Consultation Response from KC Waste Strategy

2025/91579 The Homestead, Hurst Knowle, Almondbury, Huddersfield, HD5 8SG

Demolition of the former Homestead care home and erection of 28 dwellings, comprising 20 apartments and 8 bungalows, with access from Hurst Knowle and associated external works including landscaping

Responding Ref: WPS 25 031

SITE PLAN - PROPOSED

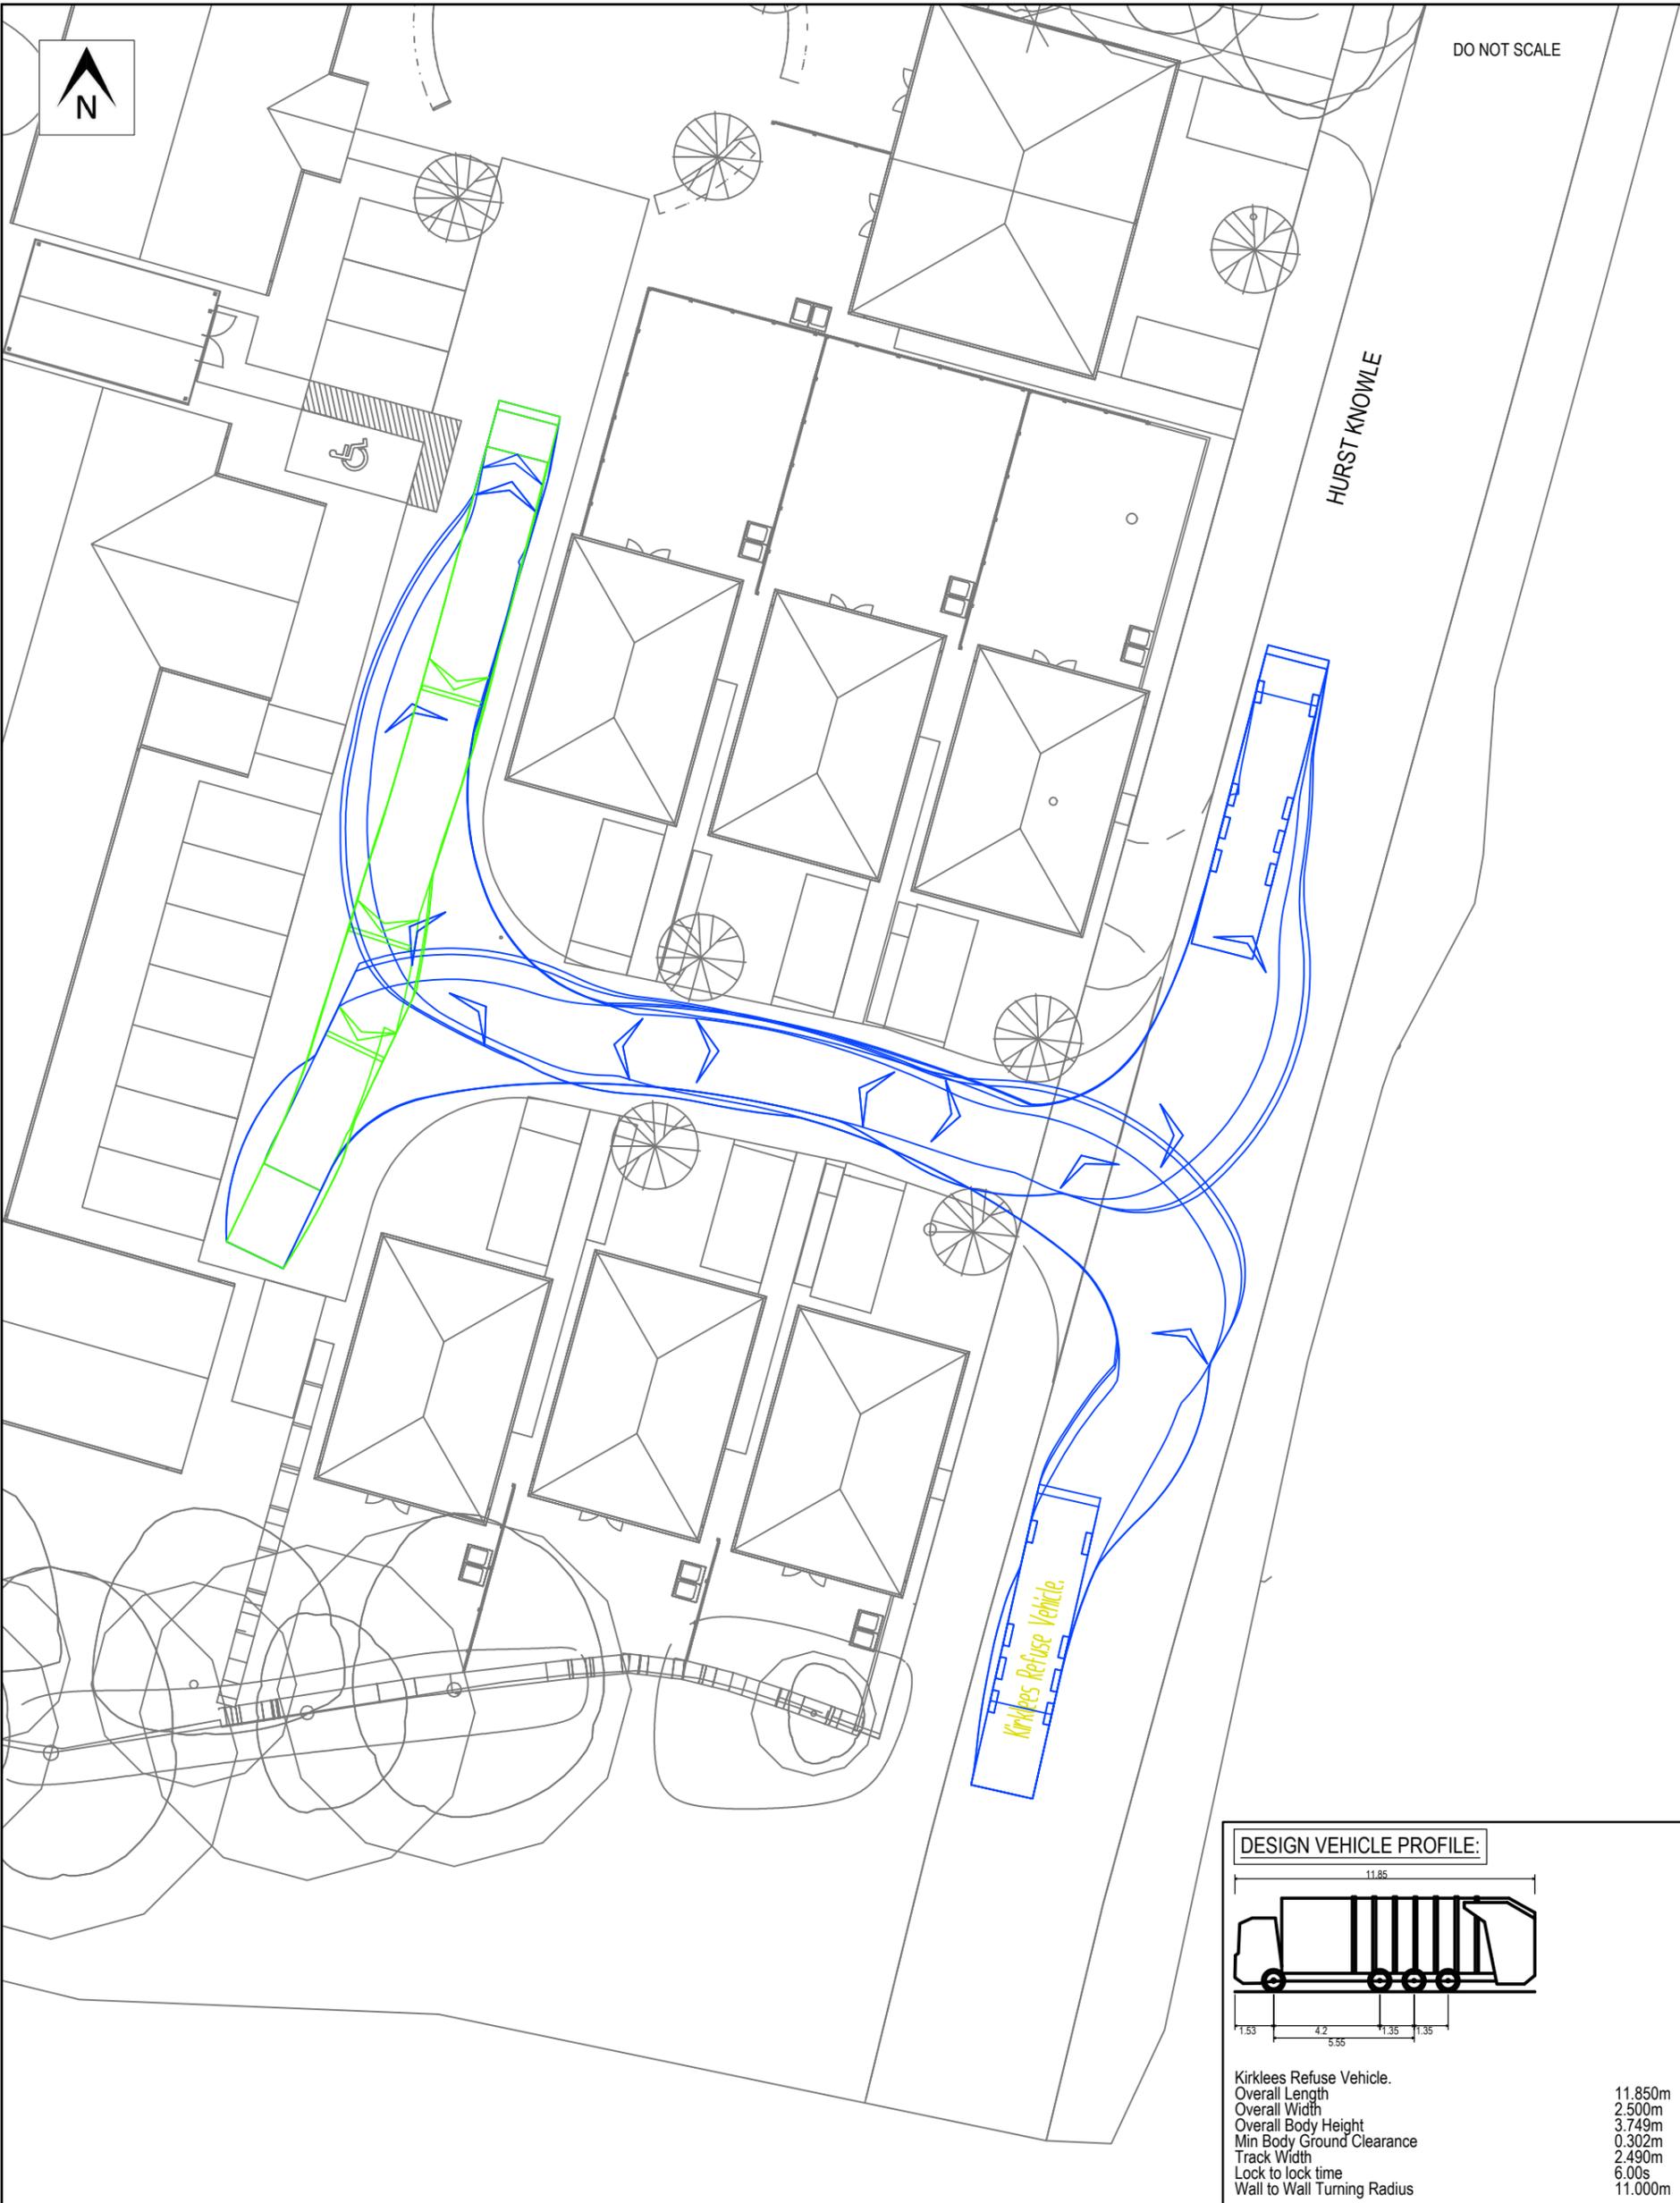
- Access to and from the bin storage area should be constructed to withstand point loading and movement, impacts of larger bins over time, and to resist future rutting, pitting, cracking or other such surface degradation that would impair bin manoeuvring. From the plan the bin store appears to be readily accessible with minimal drag out distances.

- The road slope from Hurst Knowle to the flats should be no more than 1:12.
- It is important that there is sufficient room for the RCV to turn into the site and reverse to the bin store. If parked cars are an issue on collection day, then site staff will need to bring the bins from the waste store and place them near car parking space marked 6 on the drawing and replaced after they have been emptied. This will allow the RCV to reverse directly on to the site and collect the bins.

PLAN
1 : 50

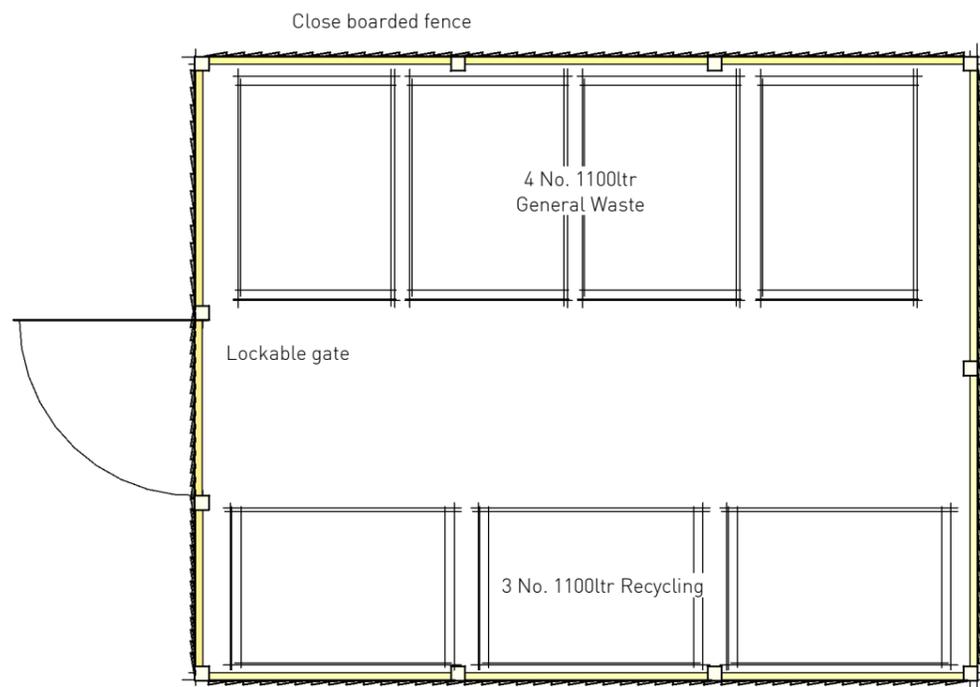
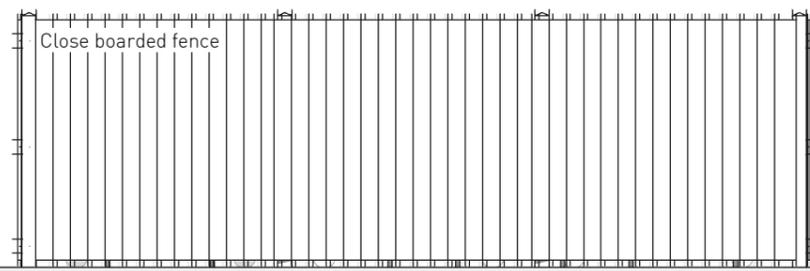
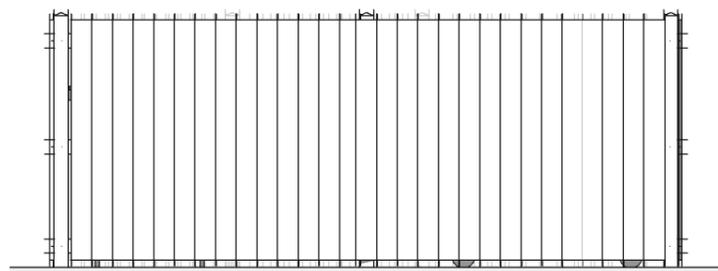
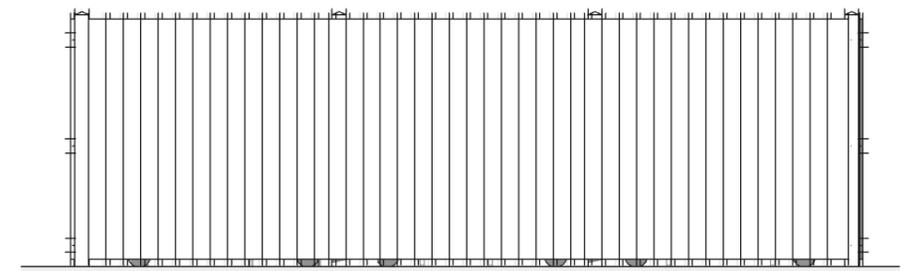
- Any waste store should be secure to prevent theft, unauthorised use / fly tipping or rough sleeping. If there are doors to the bin store and have a key / keypad to secure them these access details will be required by the collection staff. It should also be of suitable dimensions to accommodate the necessary bins and constructed in compliance with the details specified in the design guide.
